Our Ref: Gos395 A1519354  
Your Ref: 11/18834

**Re: State Significant Development Wallarah 2 Coal Project (SSD 4974) Environmental Impact Statement.**

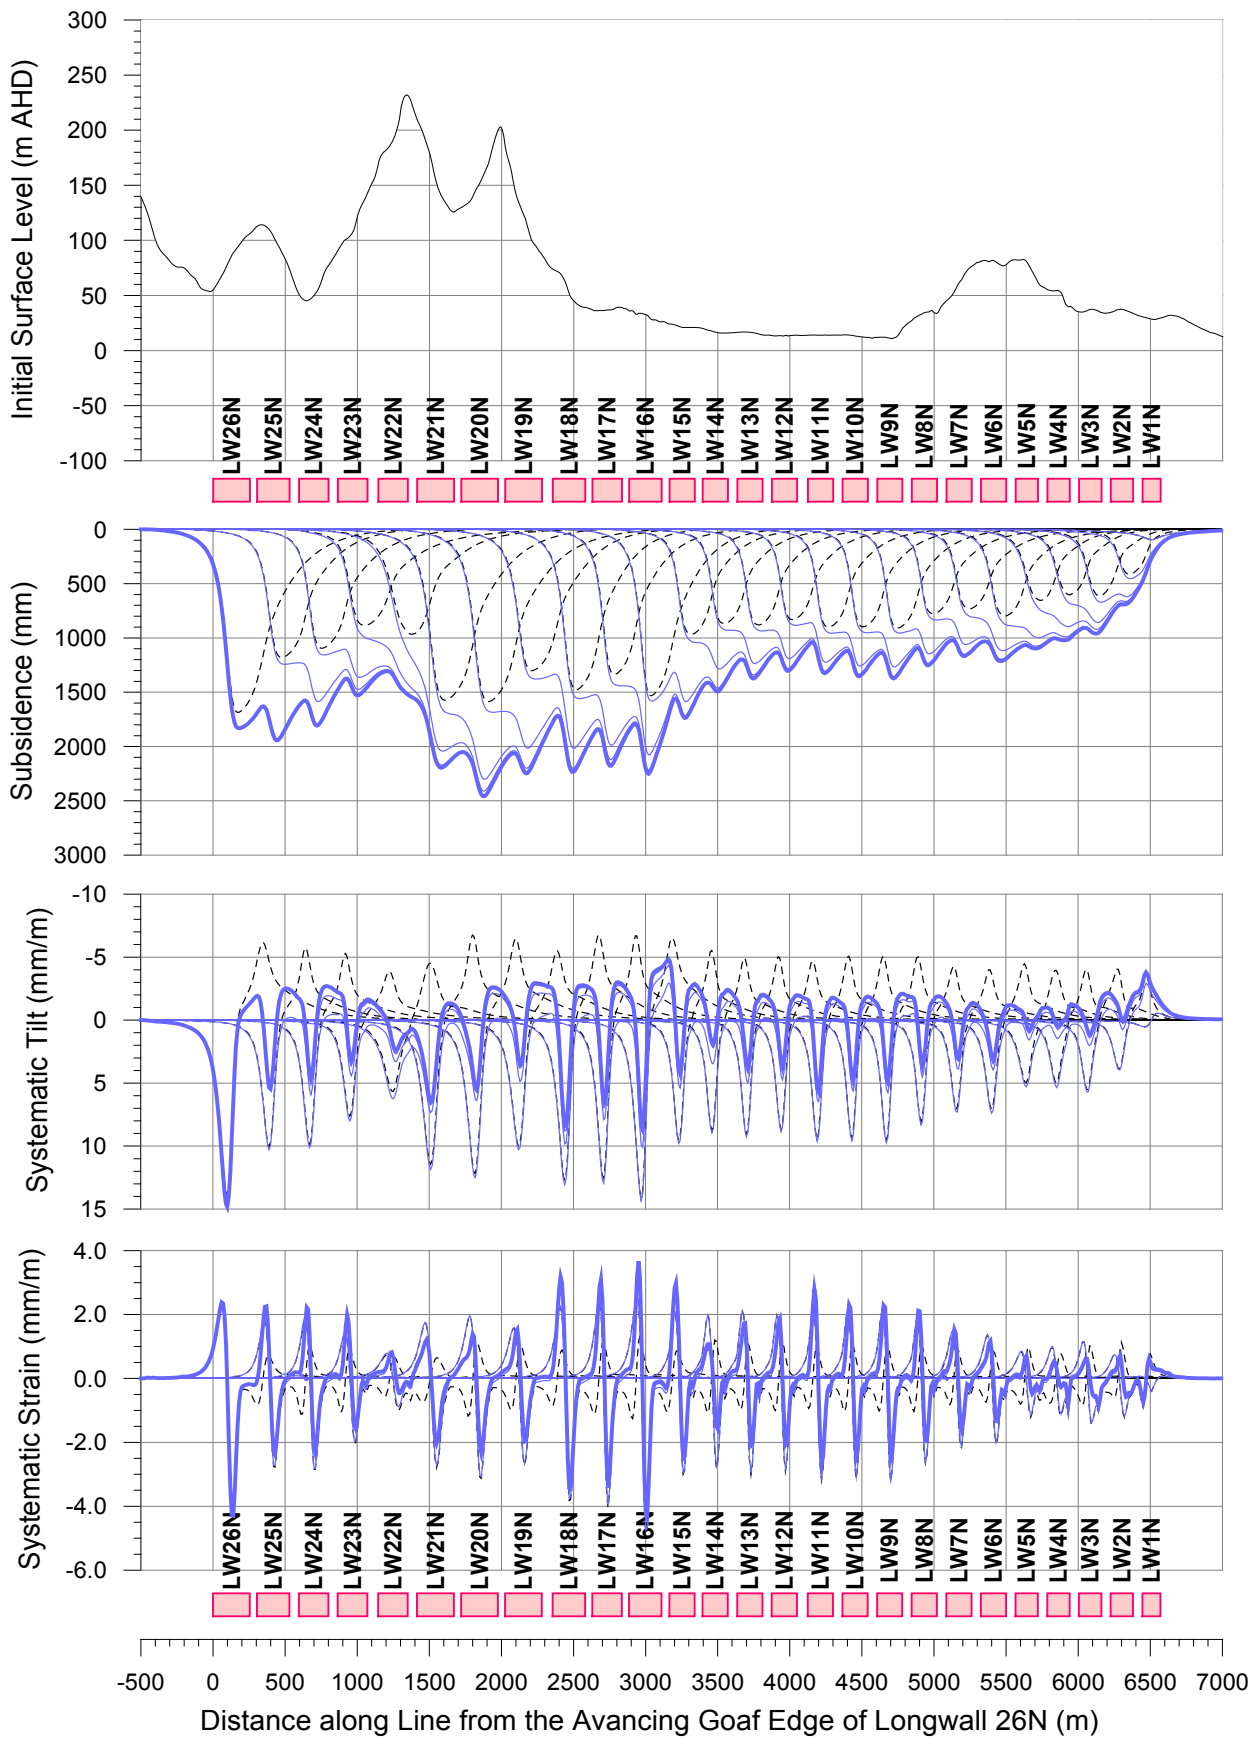
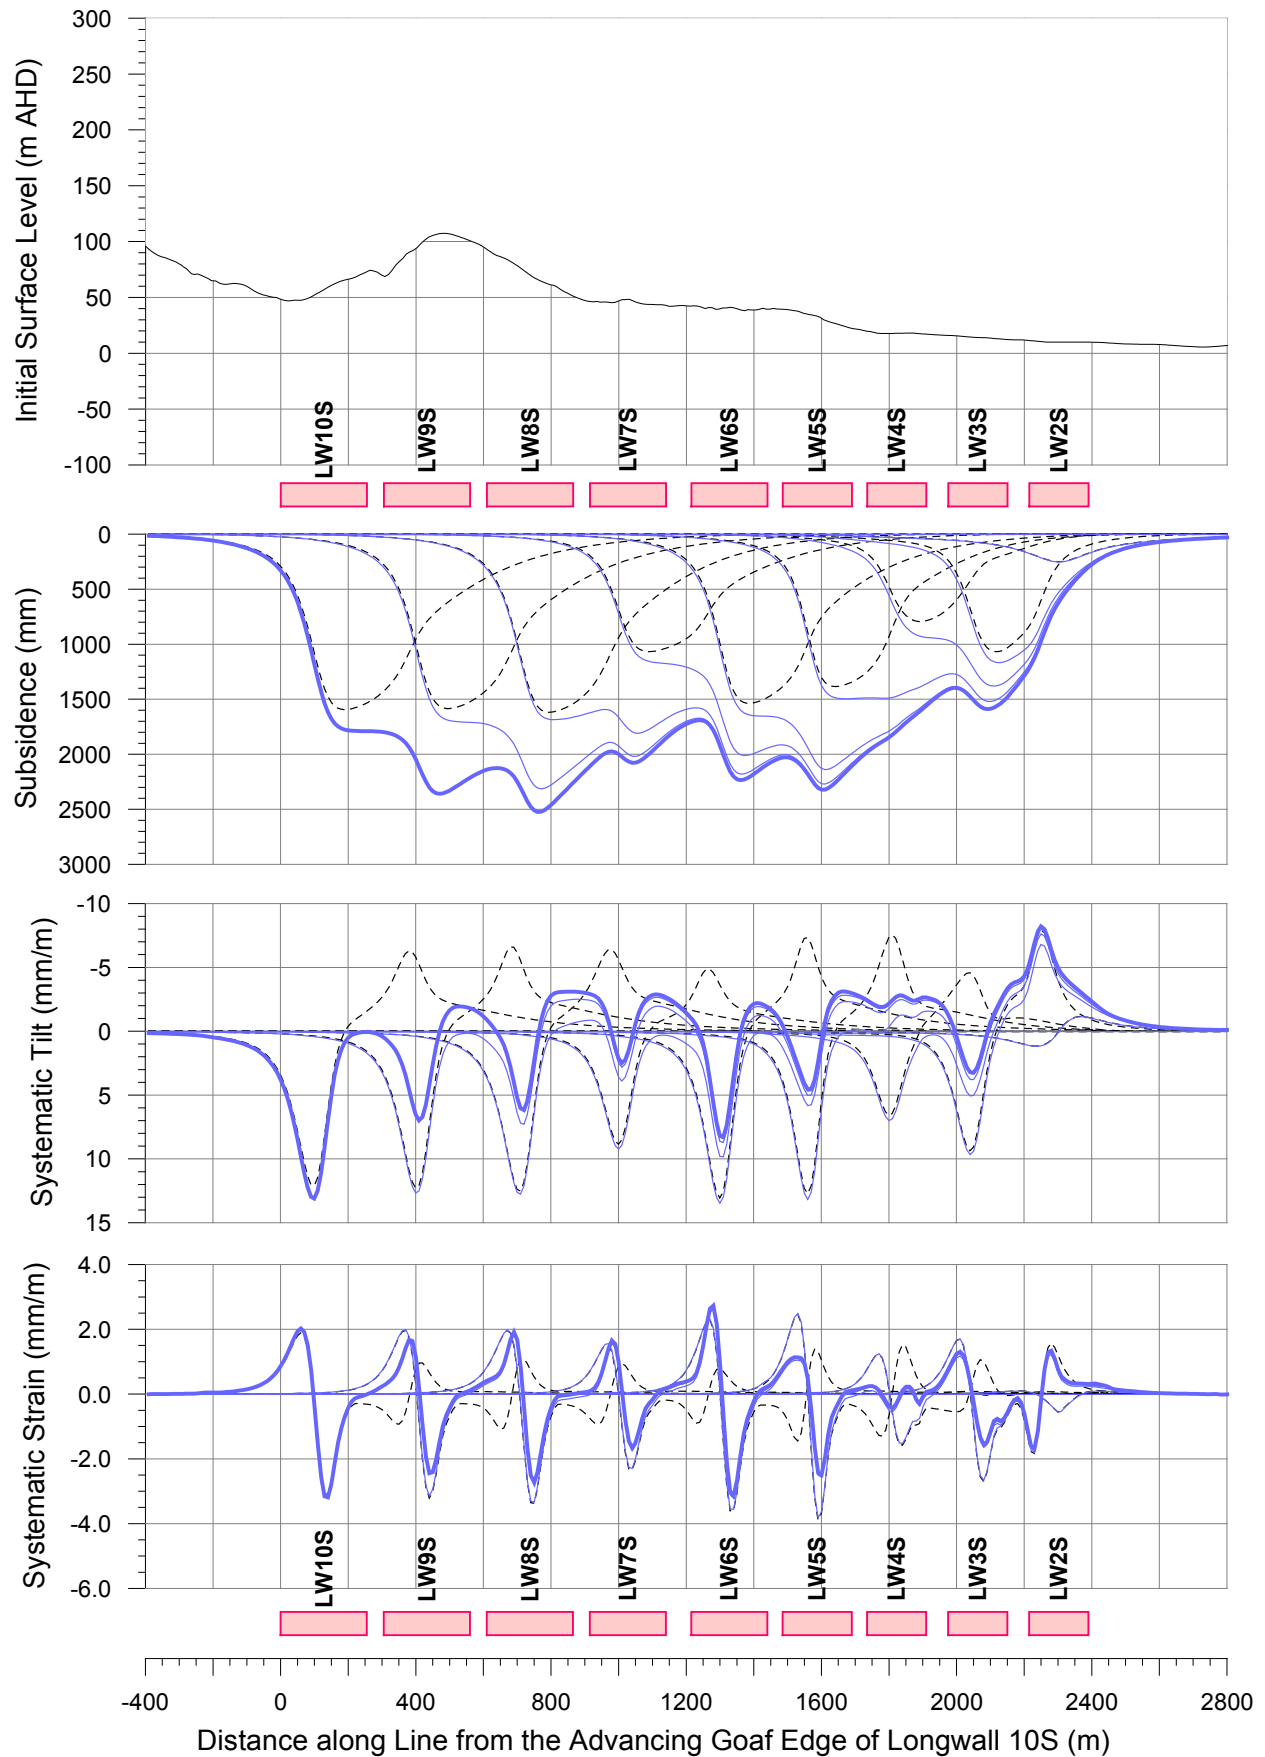
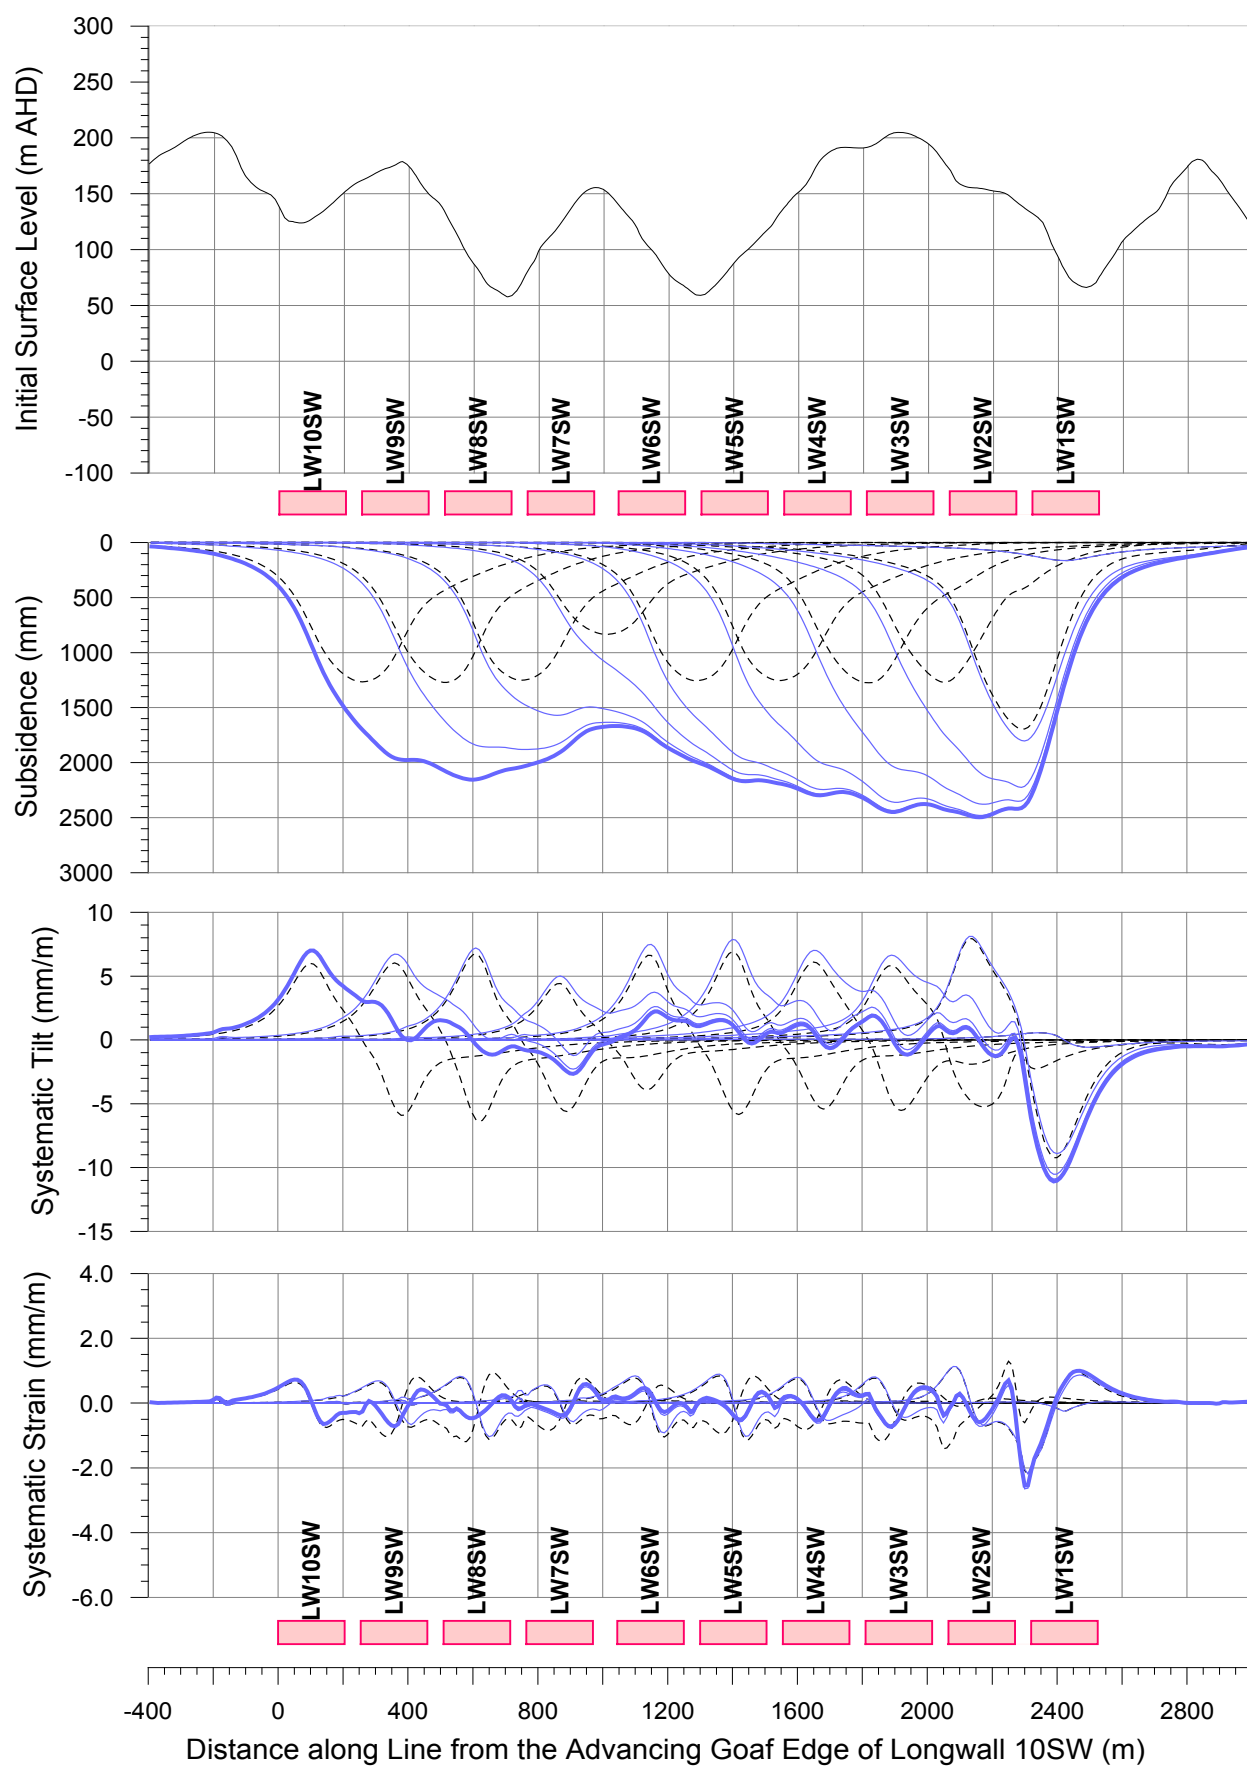
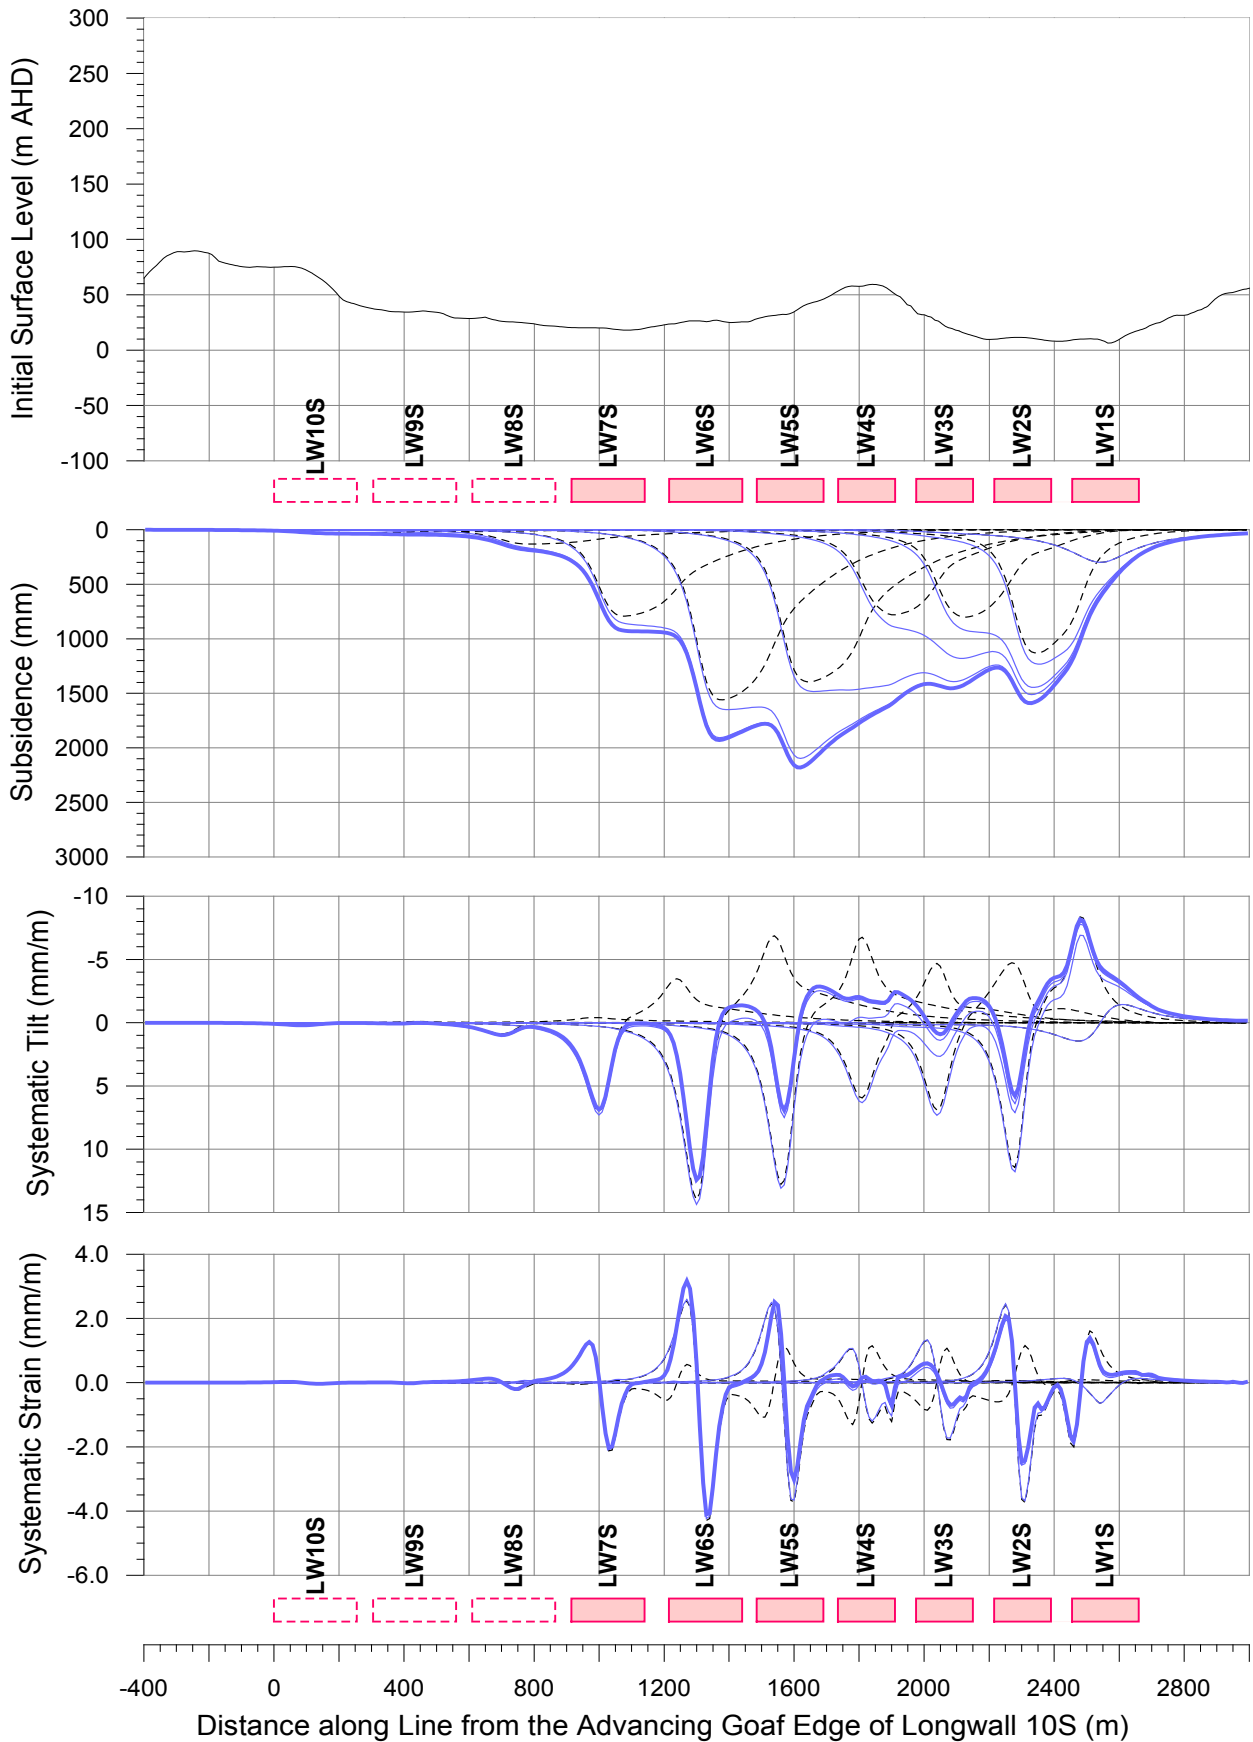
Subsidence modelling in the Wallarah 2 EIS predicts subsidence induced tilt at a maximum of 1.0% along the lower reaches of Jilliby Jilliby Creek. The current bed gradient in the alluvial stream within the mine footprint is 1.3 mm/m, or 0.13%. The increase in bed gradient as a result of subsidence is by more than 7.6 times. This has the potential to induce bed incision in high flows and the formation of a knick-point or series of knick-points that erode rapidly upstream, beyond the footprint of the mine. Established literature provides many examples of measured rates of knick-point migration in alluvial streams caused by a range of factors, including base level change.

Although the EIS considers riverbank and bed instability due to subsidence a likely occurrence, it is predicted to remain localised, despite the lack of natural bed controls in the lower catchment. The EIS also proposes several measures to mitigate damage caused by subsidence, however discussion of these issues is brief and the mitigation measures are inadequate; a response is triggered only after erosion has been observed.
